Our reference: SF 14/6436: DOC14/49983
Contact: Ramya Gowda, 02 68 835 330

I refer to the State Significant Development Application, Environmental Impact Statement (EIS) and accompanying information provided for the Parkes Hospital Redevelopment (Ref: SSD 6107) received by the Environment Protection Authority (EPA) on 12 March 2014.

Proposed Recommended Conditions of Consent

**Figure 1: Site map illustrating nearest sensitive receivers and noise measurement locations**

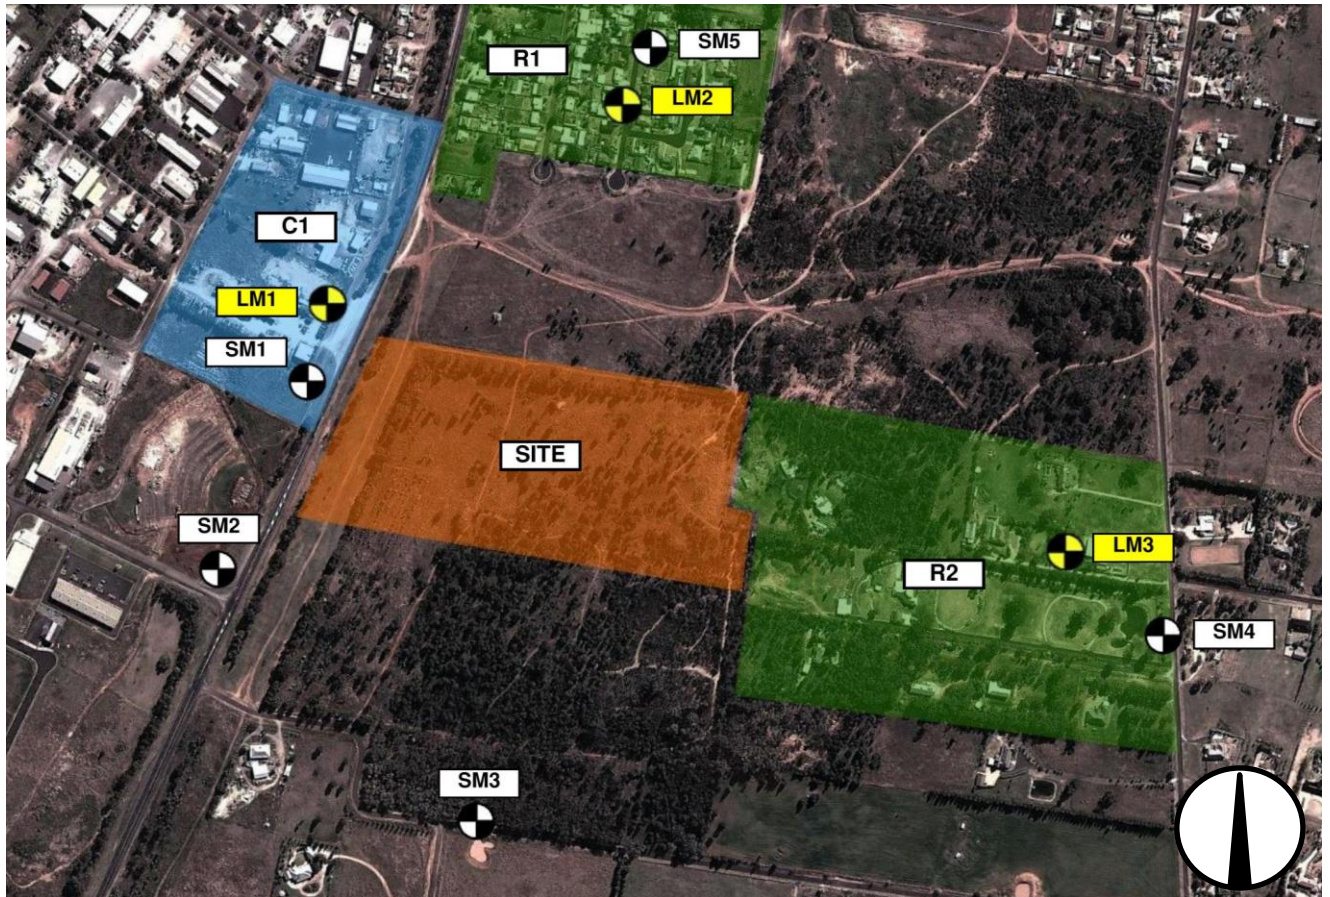
The EAA did not identify the Crown Reserve (for “community forest purposes”), immediately south of the proposed hospital, as a sensitive receiver. If it were considered as a sensitive receiver the “passive recreation” acceptable amenity level of L_{eq} 50 dBA (when in use) would apply.

Residential receivers to the south of the proposed hospital were not considered as sensitive receivers. As the noise environment in the locality of the proposal appears to be largely driven by road traffic on the Newell Highway, it is likely that the noise environment at these receivers is similar to that at receivers to the north and east of the proposal and therefore the same PSNL could be applied.

The EPA has reviewed the EIS, EAA and CNVMP and considers that residences to the south of the proposed development and the Crown Reserve adjacent to the proposal should be considered as sensitive receivers.

The EPA recommends that in this case, approval is given for the proposal based on it being designed, constructed and operated to meet the Project Specific Noise Levels (PSNL) in Table 3. The evening period PSNL for residential receivers has been revised from the version presented in the EAA to be no greater than the daytime period PSNL, as suggested by the Application notes – NSW industrial noise policy (EPA 2013).

Receiver type	Day	Evening	Night
Residential $L_{eq(15\text{min})}$	40	40	36
Passive Recreation (Crown Reserve, L_{eq} when in use)	50	50	50
Commercial (Light Industry, L_{eq} when in use)	65	65	65
